Rezoning Transportation Analysis
Petition Number: Insert Zoning Petition #2020-192
General Location Identifier: Tax ID: 12306409

Revision Log:	Date	Description
	01-21-2021	First Review (LJ)
	03-25-2021	Second Review (LJ)
	04-19-2021	Third Review (WB)

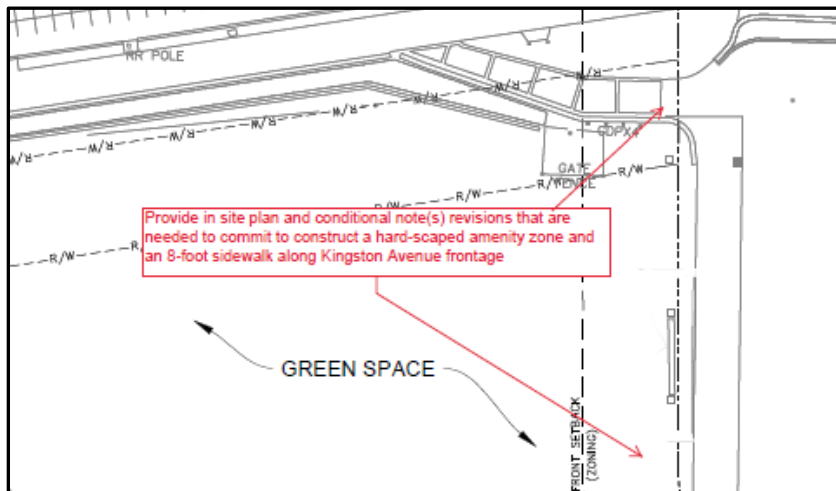
1. ~~**Curblines:** The proposed zoning district has a setback measured from back of the existing curblines.~~
 - a. ~~**Kingston Avenue:** Location of curb and gutter is in its existing location.~~
 - b. ~~Label and dimension the curb and gutter from the centerline for each road on the site plan.~~

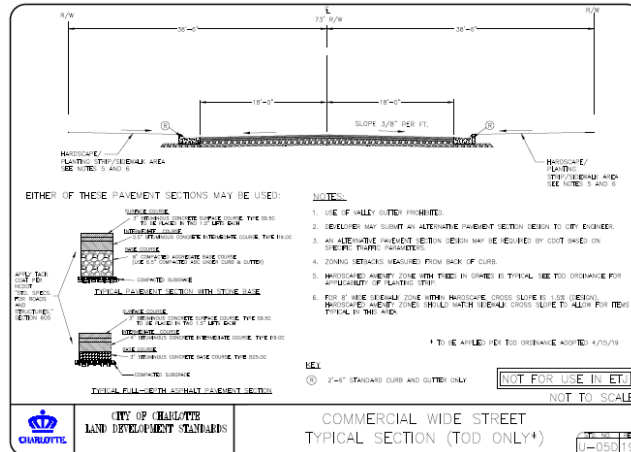
3. **Resolved (03/18/21):** ~~Revise the site plan and conditional note(s) to commit to construct a hardscaped amenity zone and an 8-foot sidewalk along Kingston Avenue frontage adjacent to proposed green space, connecting the Rail Trail access/plaza (per TOD ordinance).~~

~~Reference (CLDSM standard detail U-05D.19 [TOD ONLY]) for street typical.~~
